From: Andrew Wood <Andrew.Wood@arun.gov.uk>
Sent: 07 August 2020 10:23
To: Planning.Responses <Planning.Responses@arun.gov.uk>
Subject: AB/49/20/L - FW: Plans requested

From: Martyn White <Martyn.White@arun.gov.uk>
Sent: 06 August 2020 17:55
To: Juan Baeza <Juan.Baeza@arun.gov.uk>
Cc: Andrew Wood <Andrew.Wood@arun.gov.uk>
Subject: RE: Plans requested

Proposed Ground Floor Elevation (1:50)

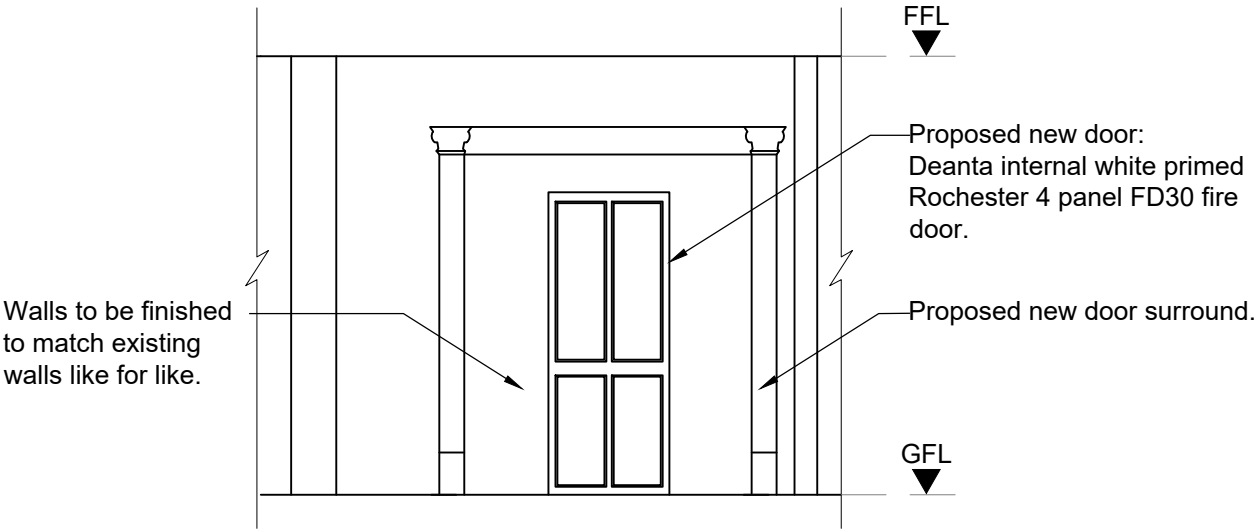
I have reviewed the attached and spoken to Andrew on the telephone today. When we spoke Andrew confirmed that the existing rear traditional door will be retained as part of the proposal. If the boarding is located on the

corridor side it will mean that this element of the works are acceptable. He stated that the modern door is to be removed and infilled and this is also acceptable.

Proposed New Door Surround (N.T.S)

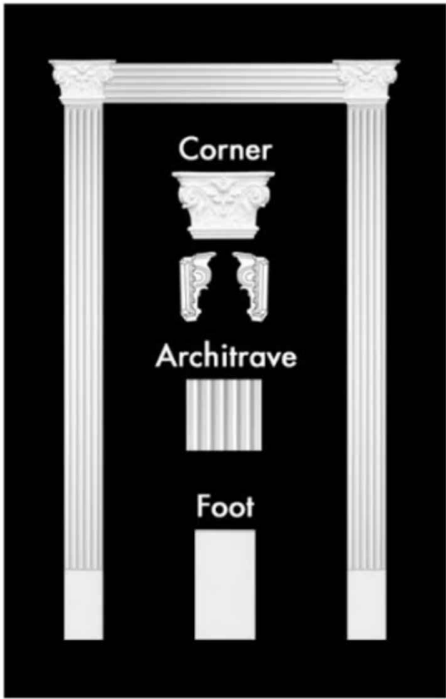
The details of the new door are unusual – in my comments I asked for details of the door surround and this is a very decorative design, a distance from the door itself. On balance, this seems to be acceptable
